Thanks for your email. We are waiting on the LLFA's further comments. Furthermore, Southern Water's response is overdue, and we will need that to finalise our recommendation. I have also just realised that our Affordable Housing consultee has not yet commented so have sent him a chase as well. I note that no First Homes are proposed so we will need his view on this. I also note that there are no 4bed units as part of the AH mix.

I also realise I had not shared with you any of my own assessment of the scheme. My own issues are as follows:

From: Rebecca Hornsby [REDACTED]
Sent: 26 May 2026 14:16
To: Simon Davis <Simon.Davis@arun.gov.uk>
Cc: Jack Karagoz <[REDACTED]>
Subject: FW: WA/18/26/PL - Land off Arundel Road

Drawing Title
Block Plan

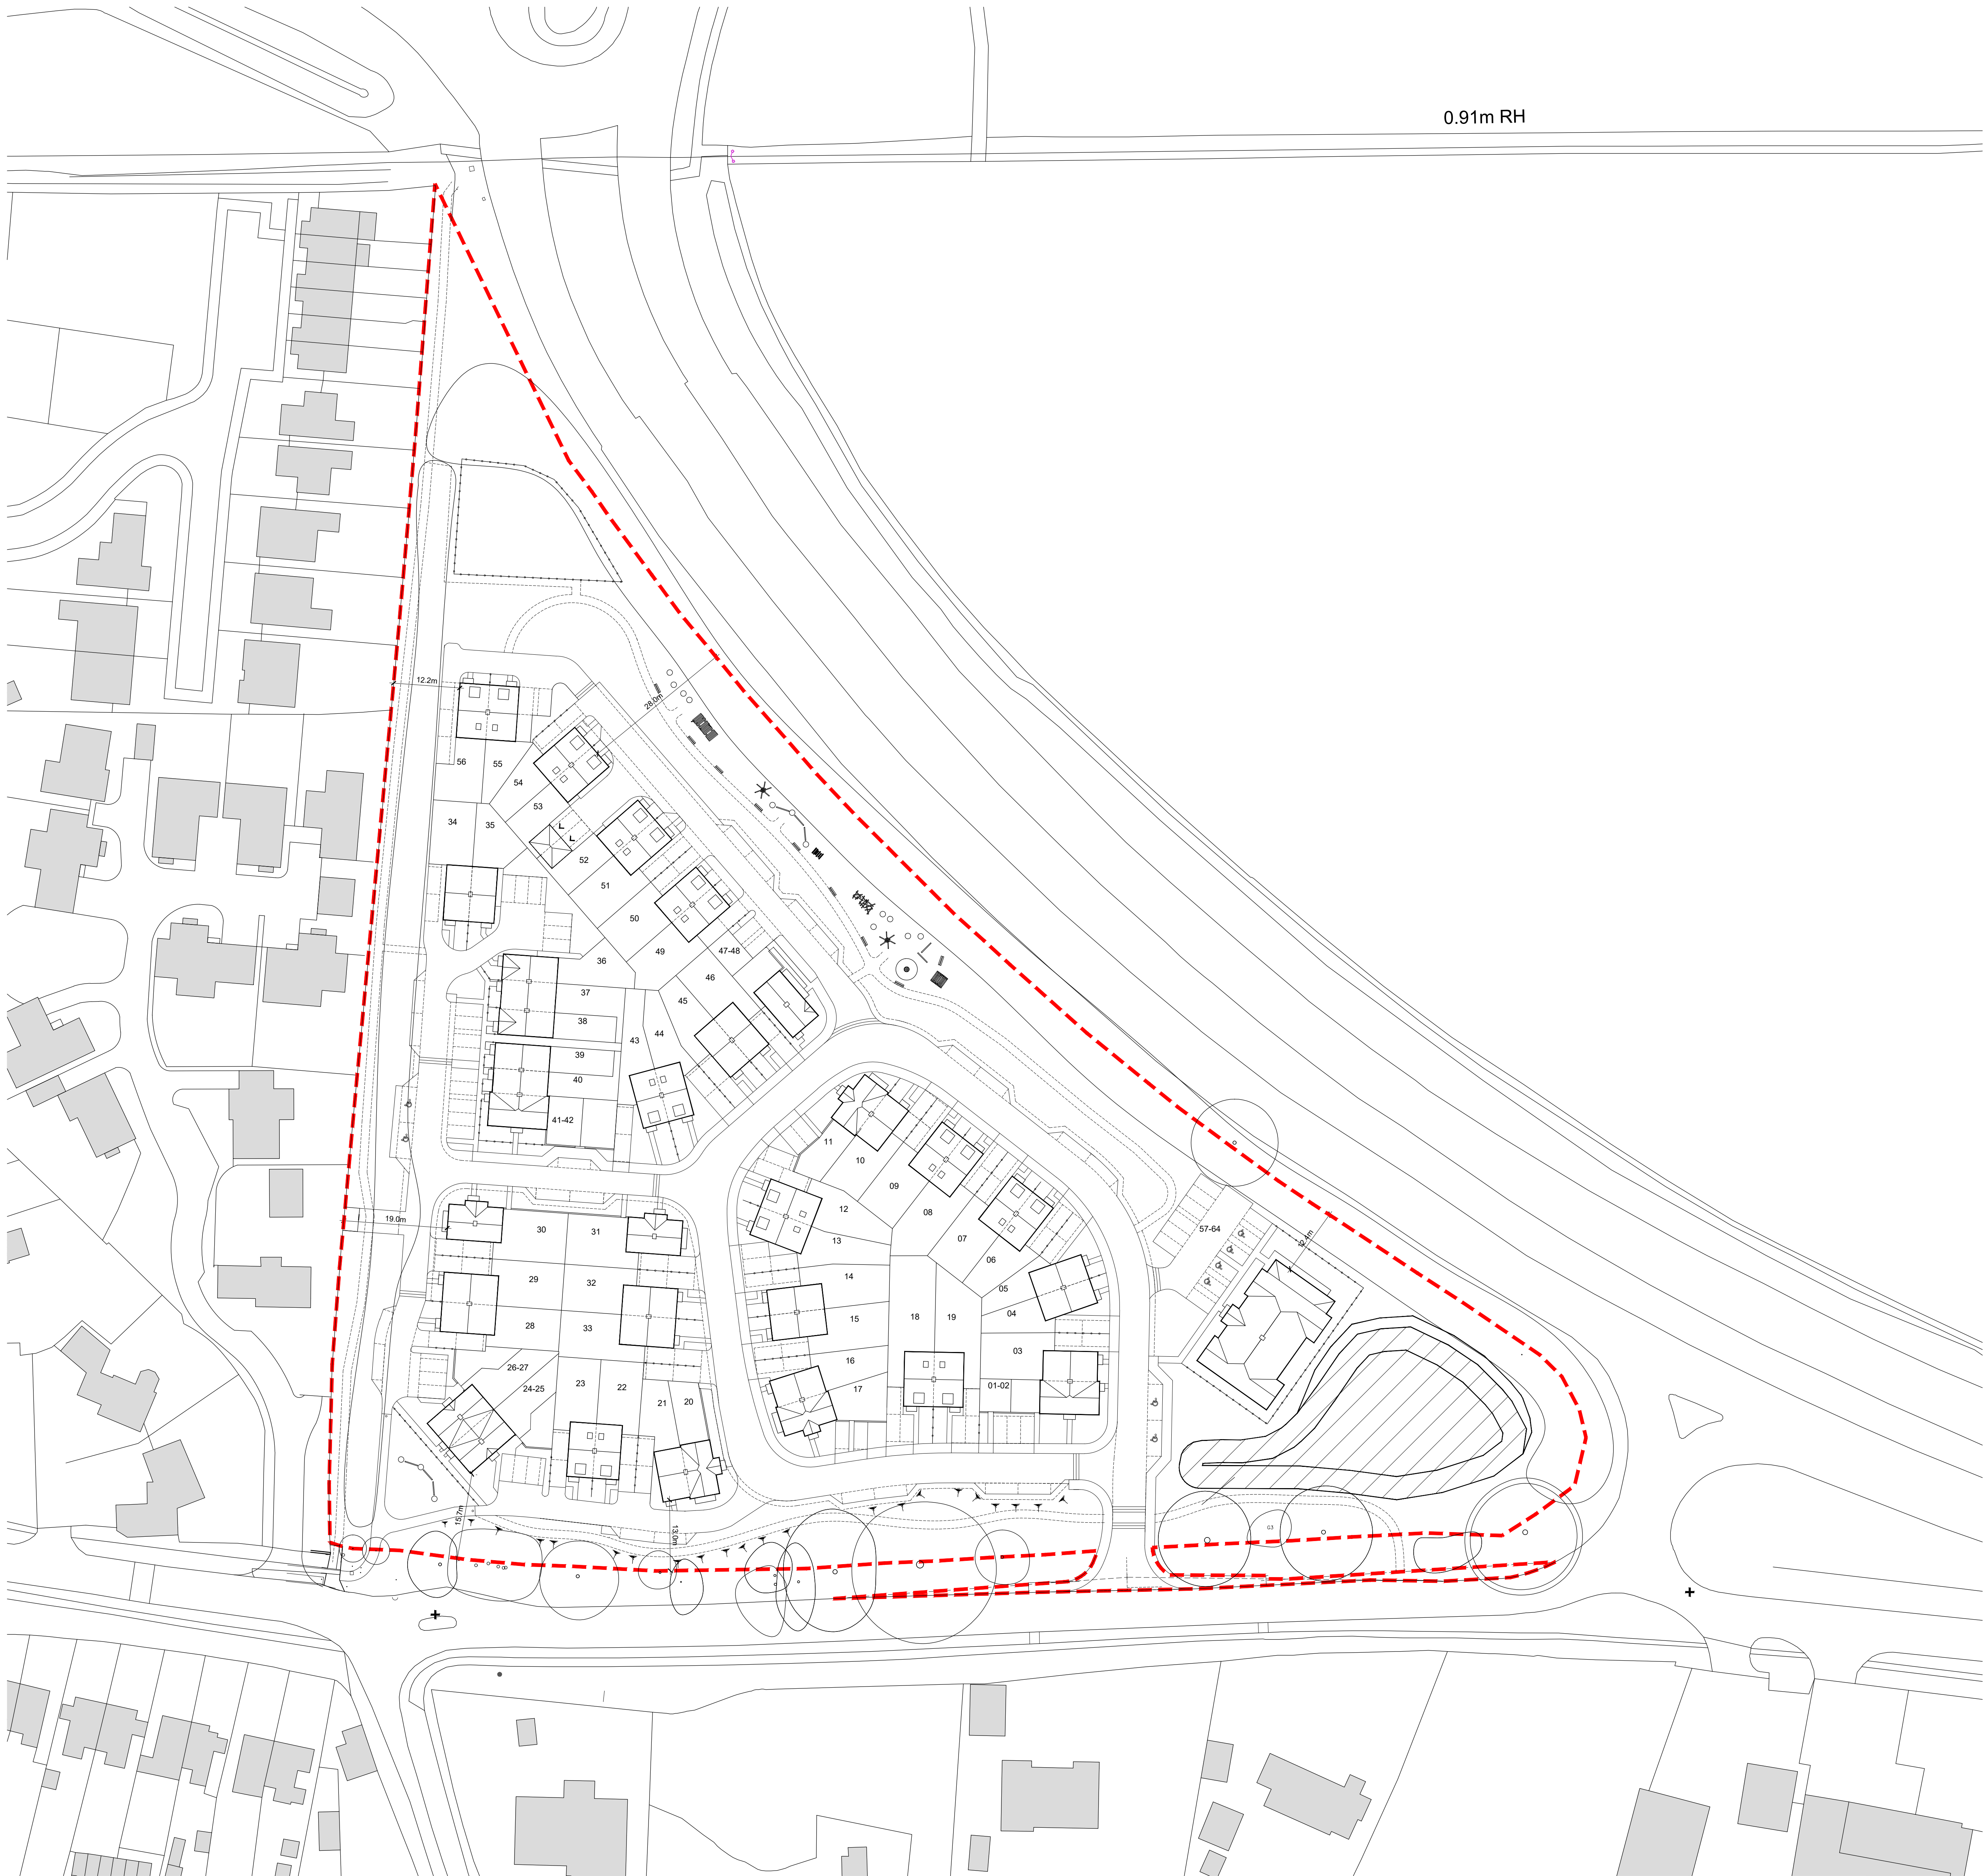
There appear to be areas where more street trees could be added (western and eastern arms of the 5.5m road).

3R to 19S is 14m (14.5m requirement per the ADG)
 1/2R to 19S is 13m (14.5m)
 17R to 18S is 14m (14.5m)
 11R to 12S is 13.5m (14.5m)
 40R to 43S is 14m (14.5m)
 31F to 43F is 14.9m (16m)
 30F to 41/42S is 12m (14.5m)

(where R - Rear, F - Front, S - Side)

Are there any aspects based on the above that can be changed?
